**SSD 8636: ENGINEERING & TECHNOLOGY PRECINCT DEVELOPMENT  
UNIVERSITY OF SYDNEY, DARLINGTON CAMPUS**

**UNIVERSITY OF SYDNEY RESPONSE TO SUBMISSIONS 2**

**9 DECEMBER 2018**

SWEPT PATH ASSESSMENT

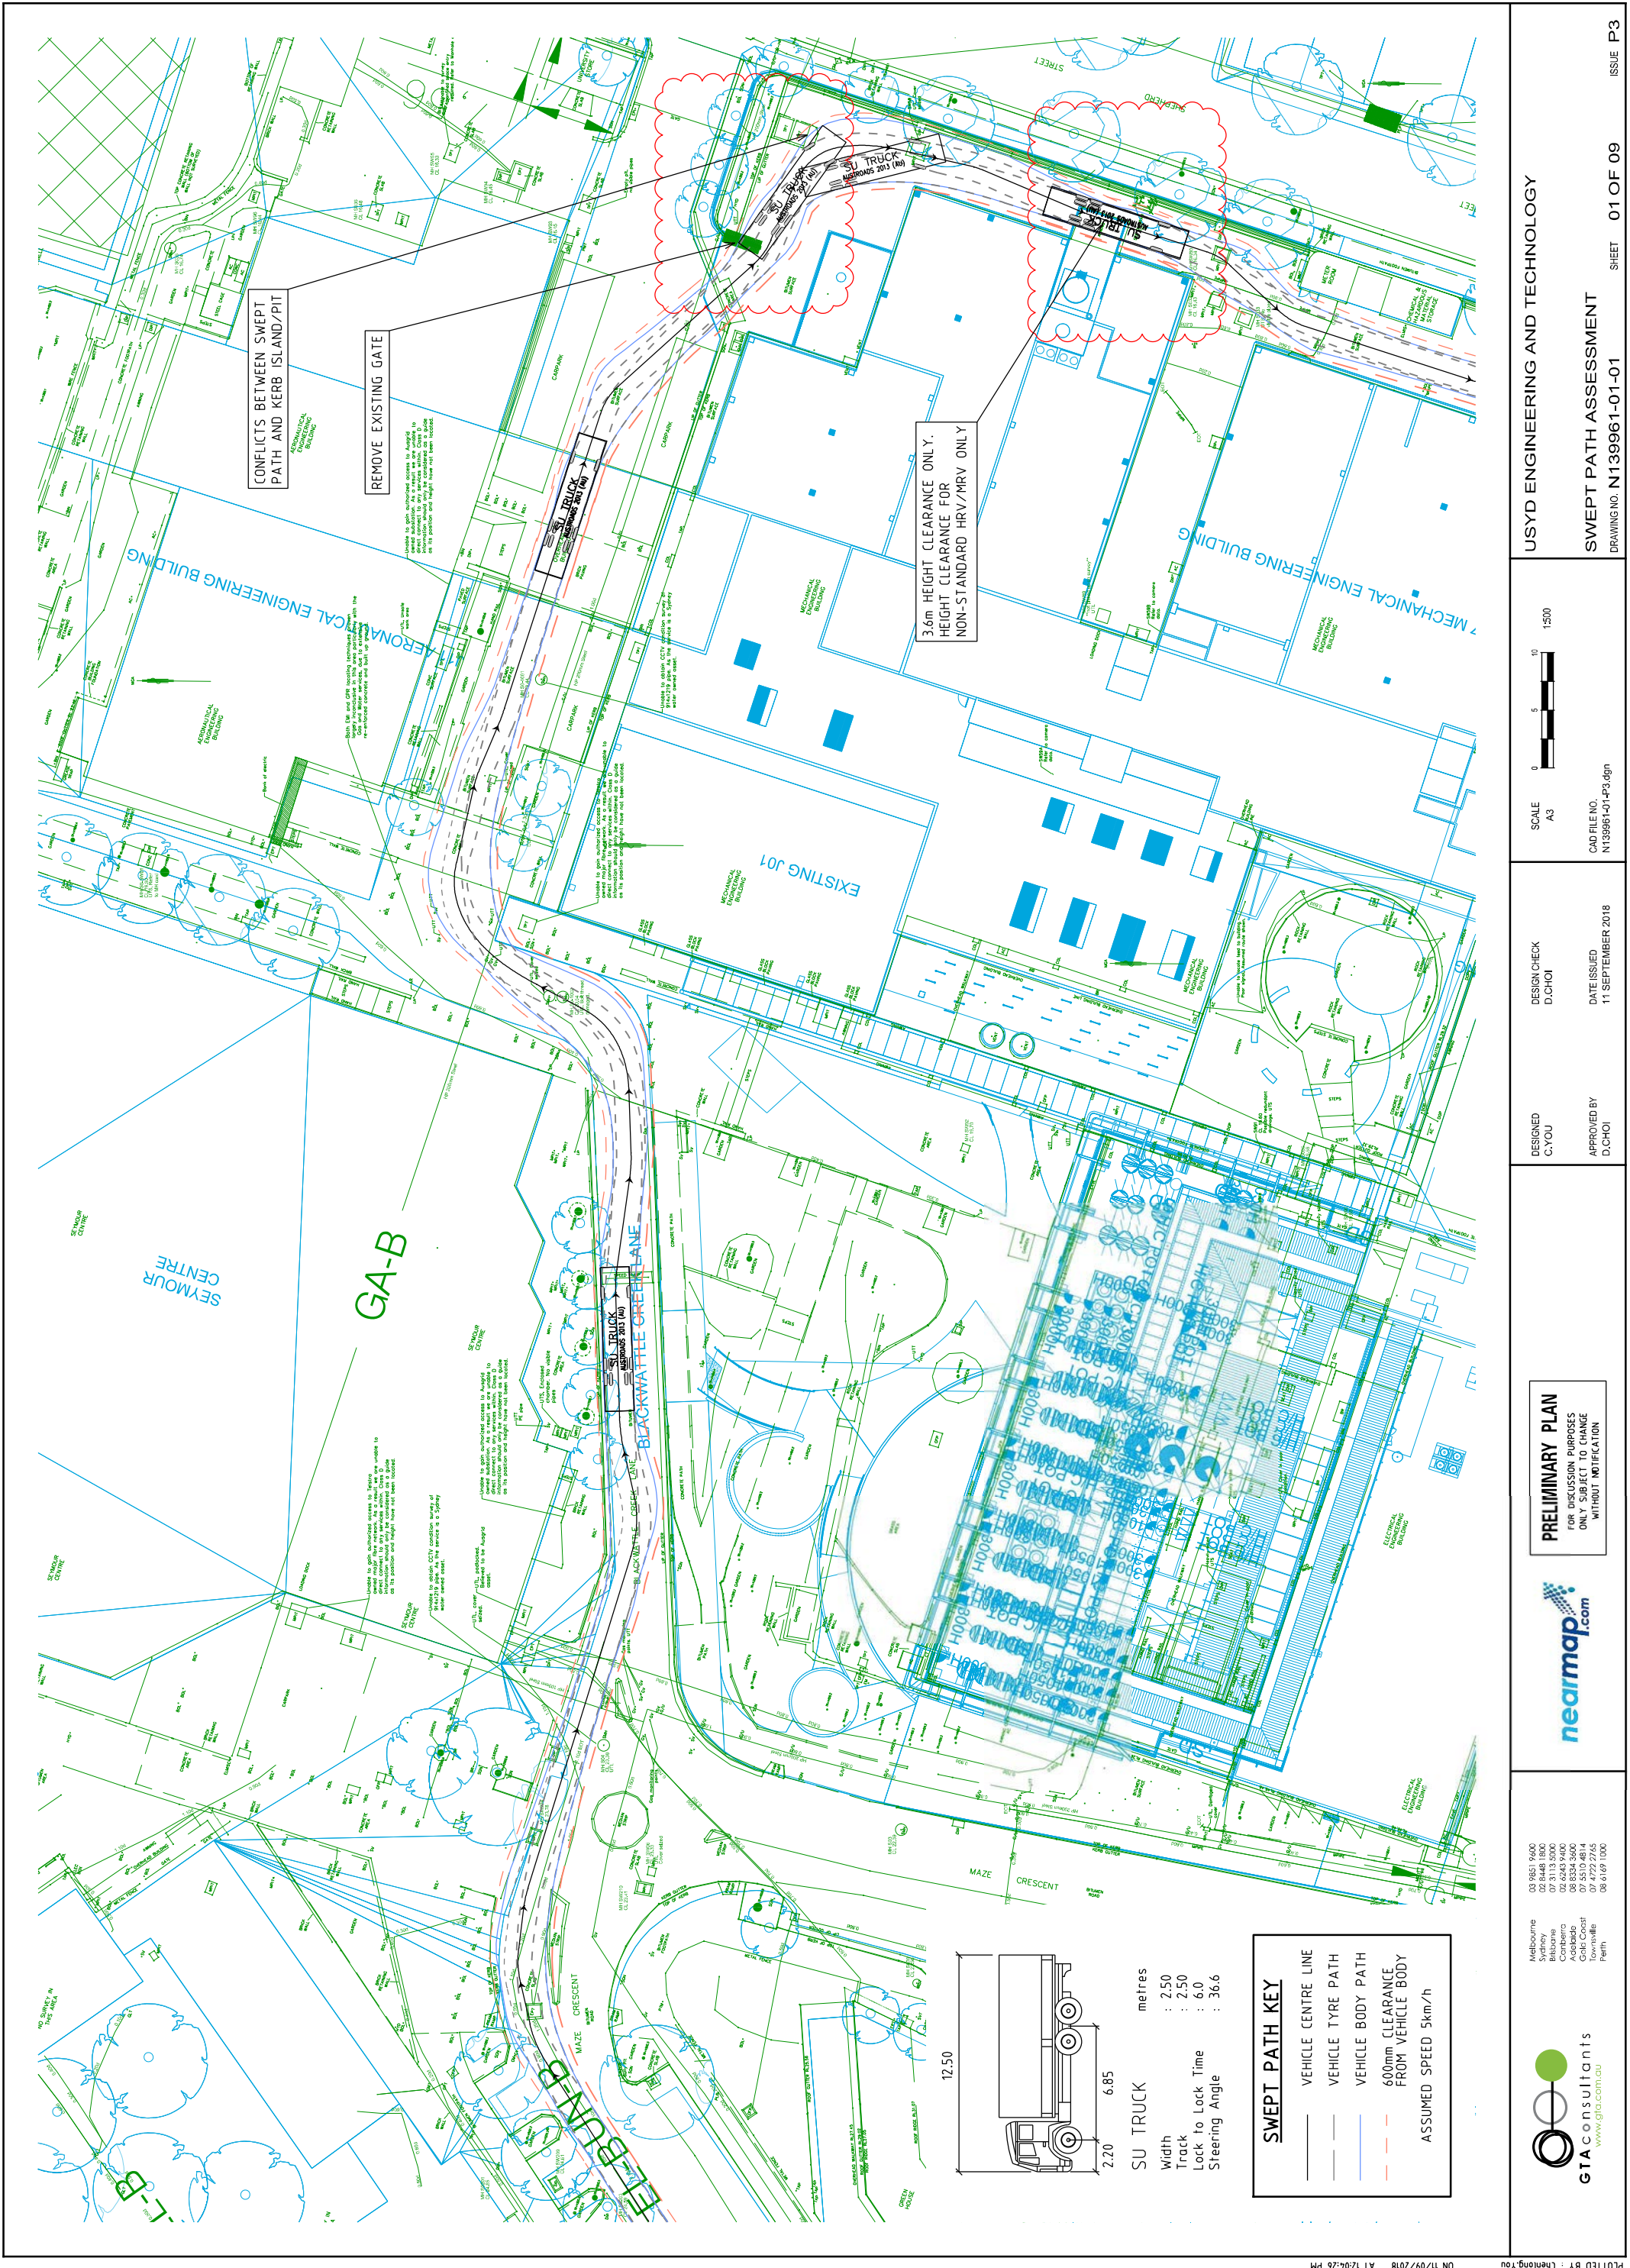
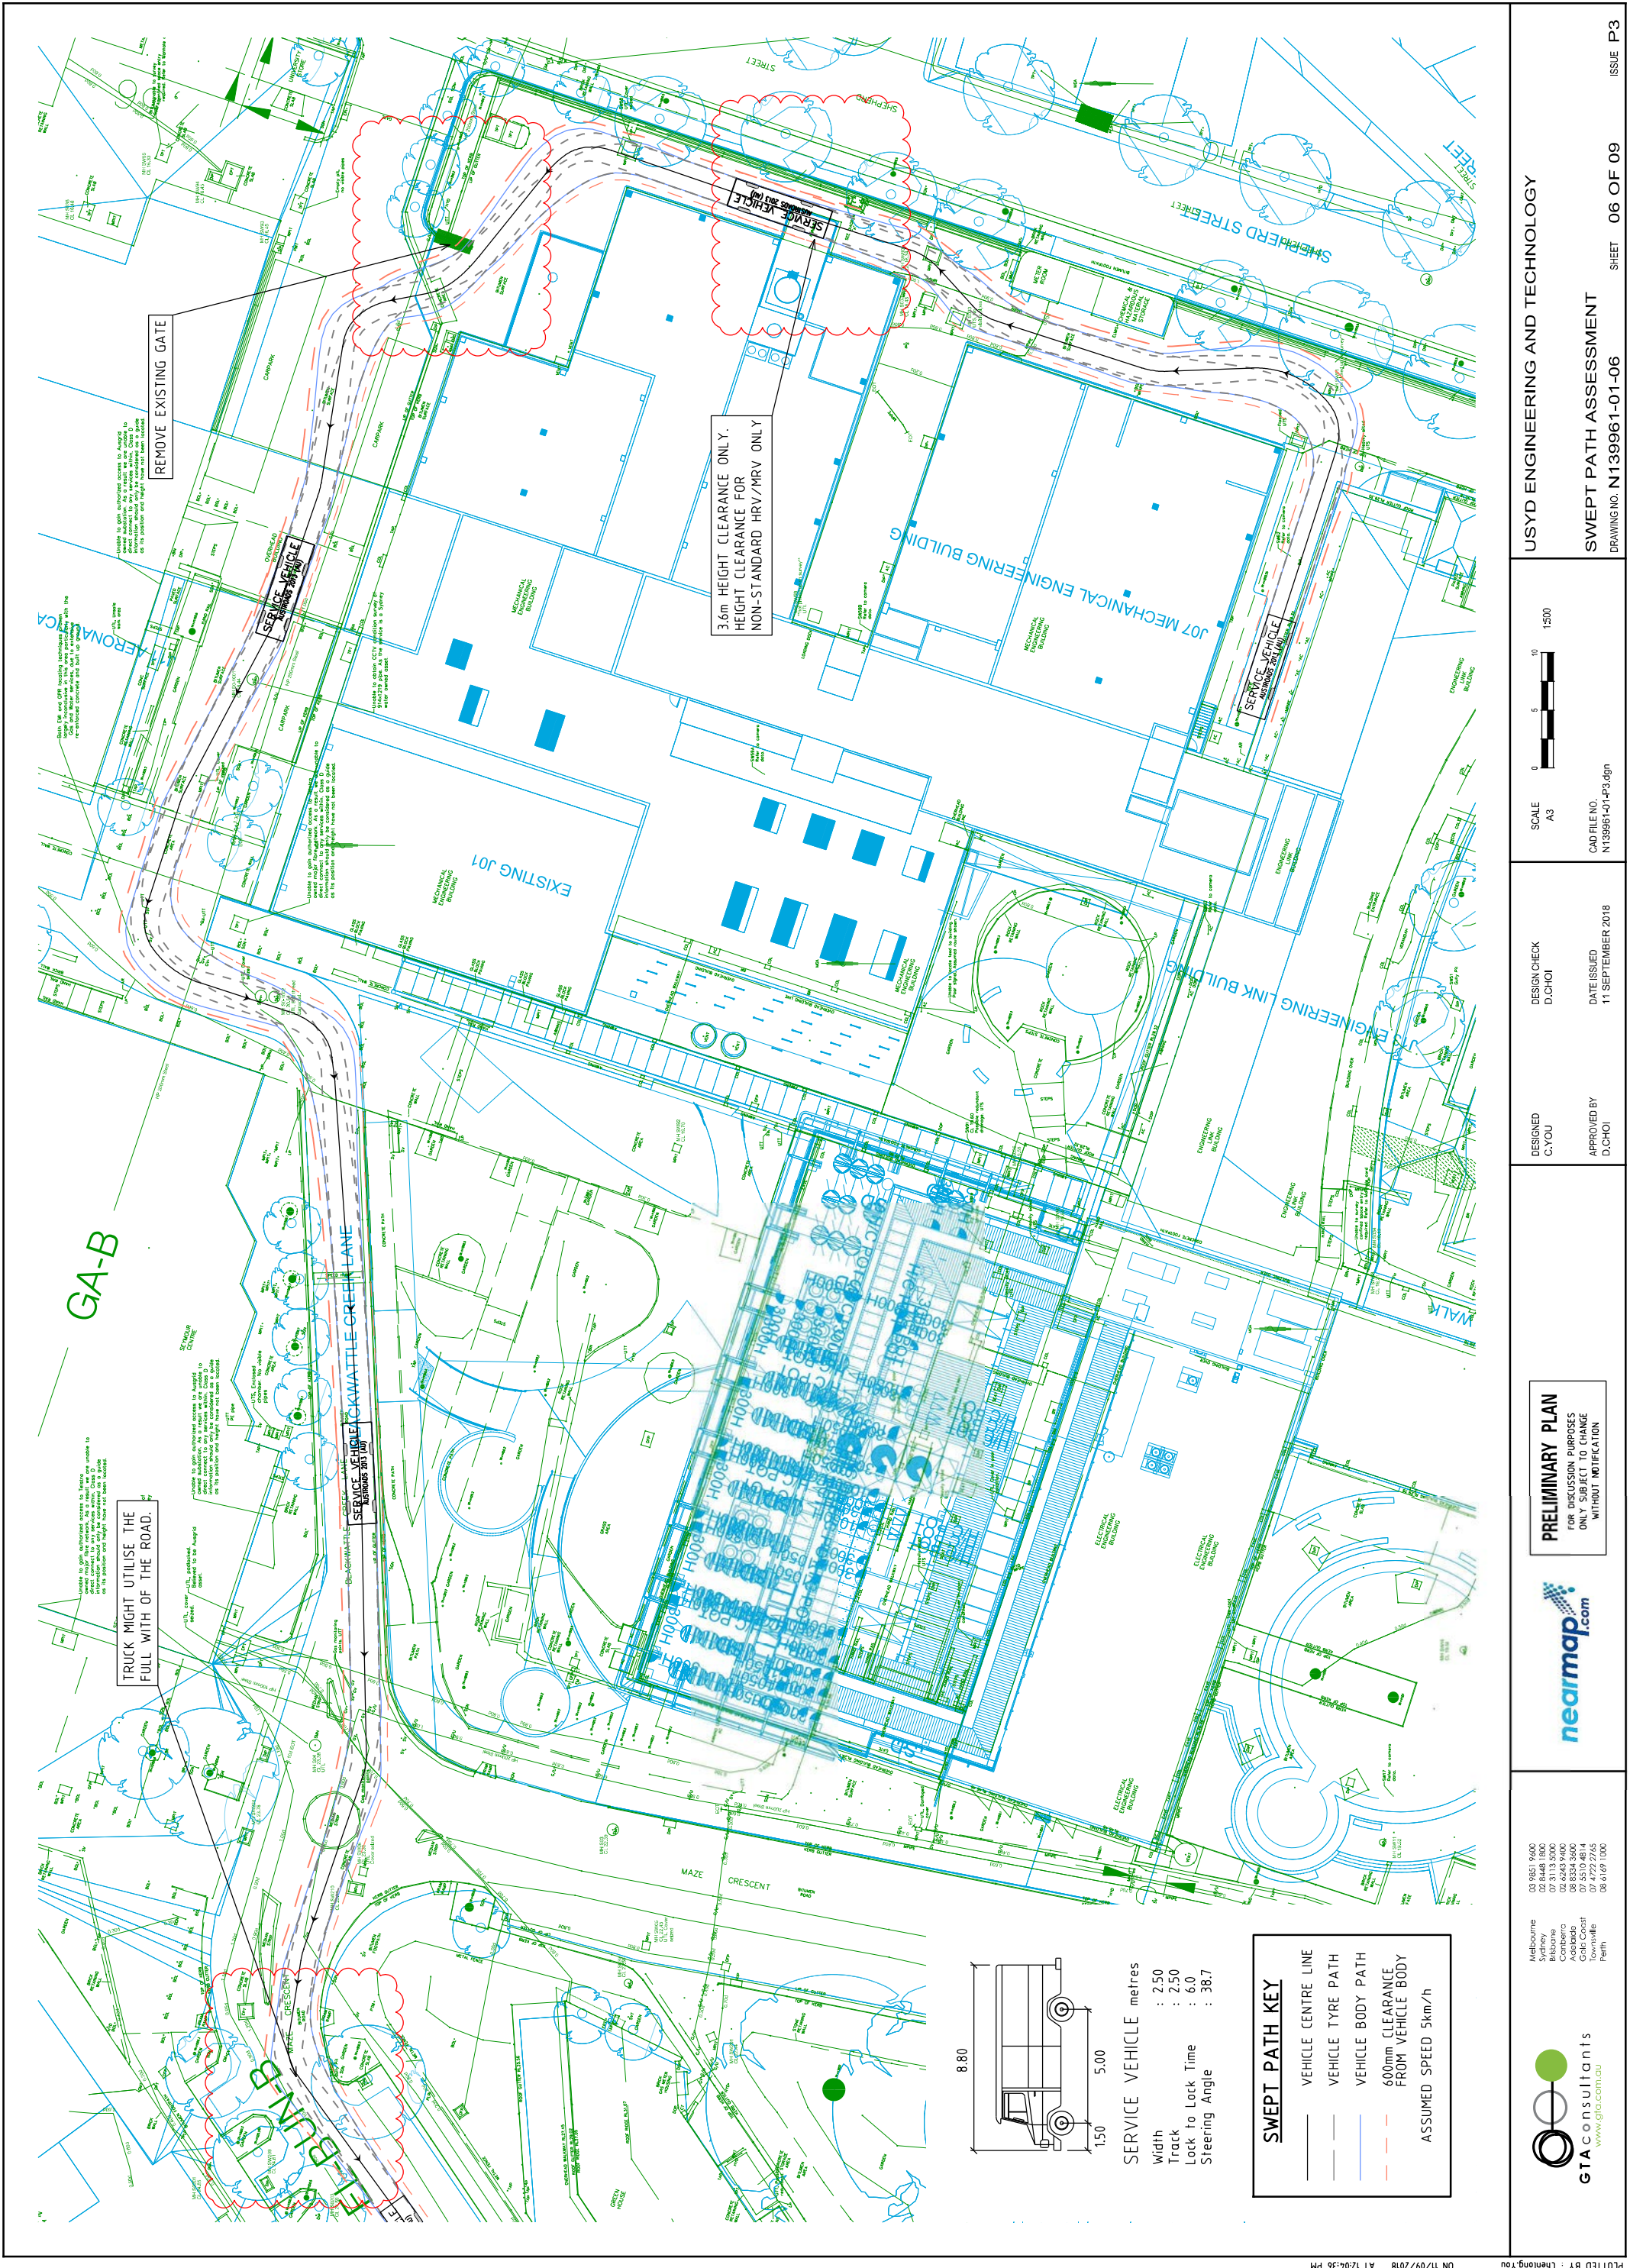
2. Swept Paths for HRVs and MRVs show a number of conflicts with existing structures, including the hazardous material storage building. The assessment does not advise how these will be resolved. Please also confirm if the swept paths would impact on the proposed new landscape works for Blackwattle Lane.	<p>Swept Paths undertaken by GTA Consultants have identified 4 areas of potential conflict with Heavy Rigid vehicles (standard 12.5m length) and existing asset interface through the proposed loading dock access route. These conflicts are identified as minor in nature and will require minimal site remedial works to ensure relevant access routes are free from obstacles.</p> <p>A resolution of conflict assessment has been prepared by GTA Consultants (contained in <b>Appendix B</b> - GTA Traffic Swept Path Mitigation Letter) providing clarity on mitigation/management arrangements that can be implemented to manage identified potential conflicts between trucks and existing structures. It is in the University's interest that the conflicts are adequately resolved prior to the operation of the new development and as a minimum implement the recommendations of GTA Consultants.</p> <p>The proposed new landscape works for Blackwattle lane to improve permeability and pedestrian flow will be coordinated with the current vehicle swept path to avoid any adverse impacts.</p>

1 SHEPHERD ST ELEVATION
A-DA-3005 SCALE 1 : 200

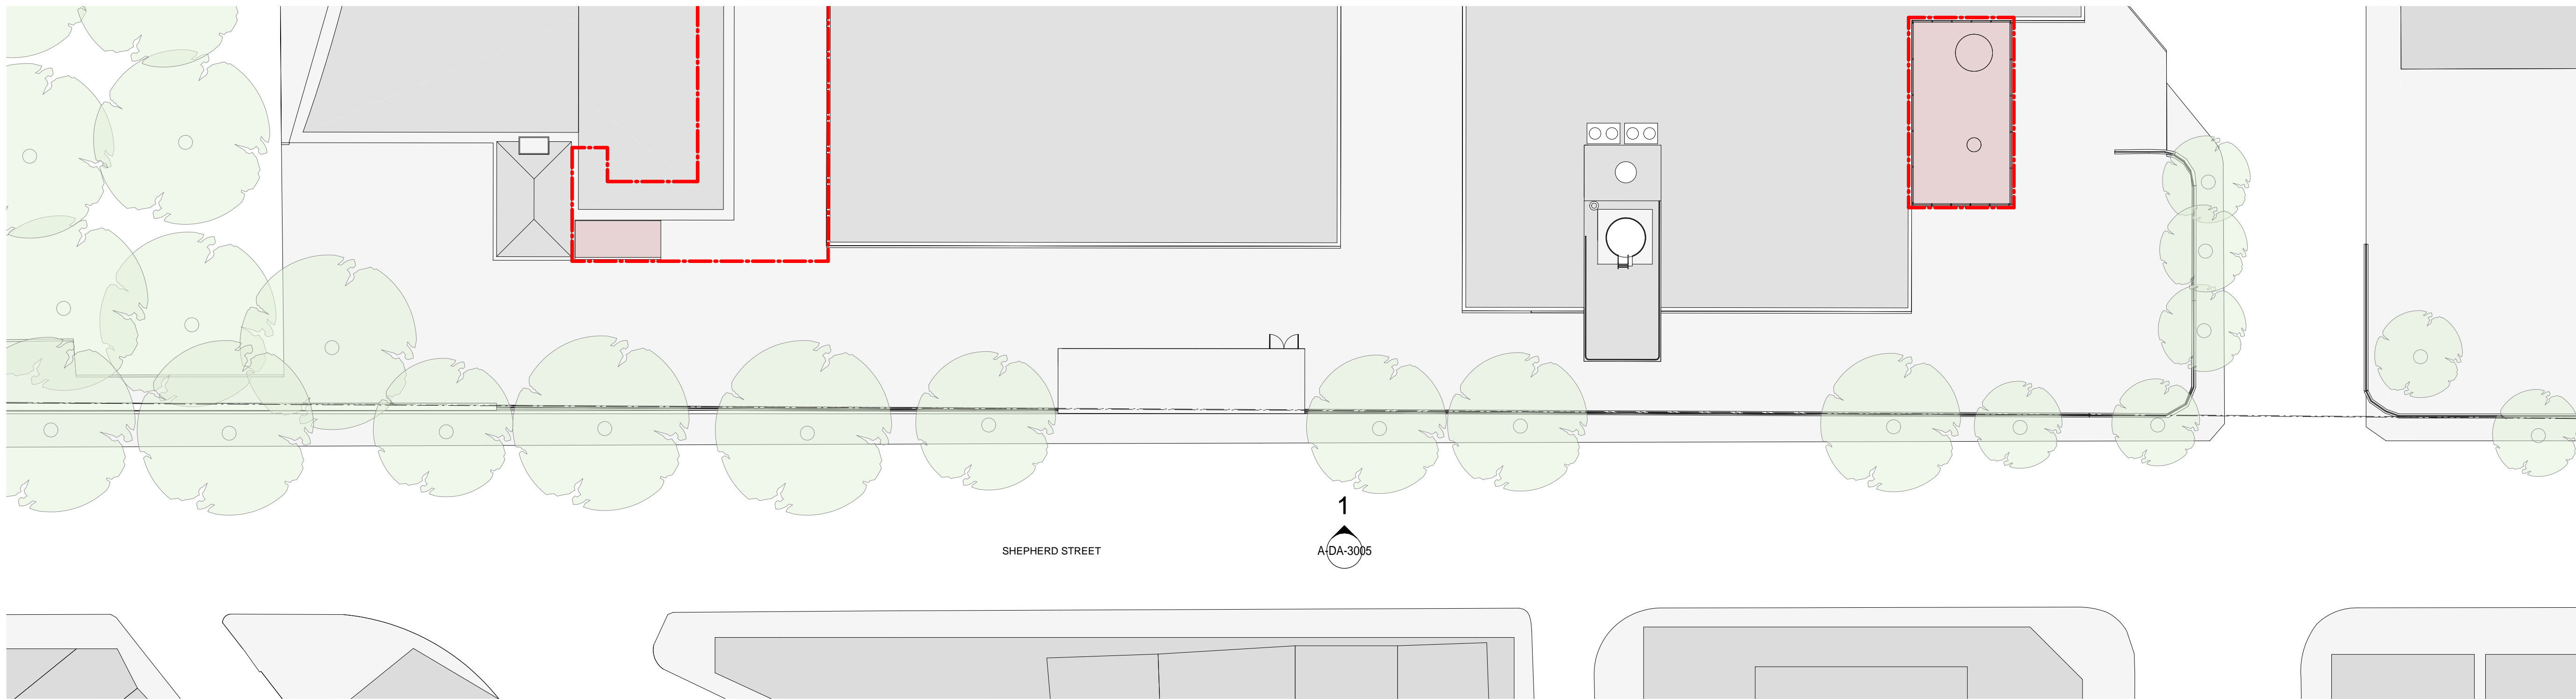
<b>Gas storage on Shepherd Street frontage</b> 3. Plans show new gas storage on both sides of the stairwell element of J13, but the elevation only shows screening on one side? If necessary, please correct the plans. Please also provide a detailed elevation of J13 showing plant and screening details, including materials. These parts of the site also include some landscaping that will be removed. Ideally replacement landscaping should be provided in front of the screening to assist with offsetting the visual impacts to Shepherd Street.	<p>The intent is to provide two similarly screened enclosures for various gas storage types on either side of the stairwell. Refer to <b>Appendix C</b> - Gas Storage Enclosure, drawing 2101B(E) &amp; VIE Tank Perspective from Shepherd St.</p> <p>The Liquid Nitrogen enclosure to the southern side of the stair will have taller elements than the Cryogenic gas store to the northern side. This enclosure is located in front of a glass-block window with relatively opaque outlook and no opening sections.</p> <p>Egress from the existing fire stair will be diverted with a solid wall behind the southern Liquid Nitrogen enclosure. Refer to <b>Appendix C</b> – Gas Storage Enclosure, Proposed alterations to existing building</p>
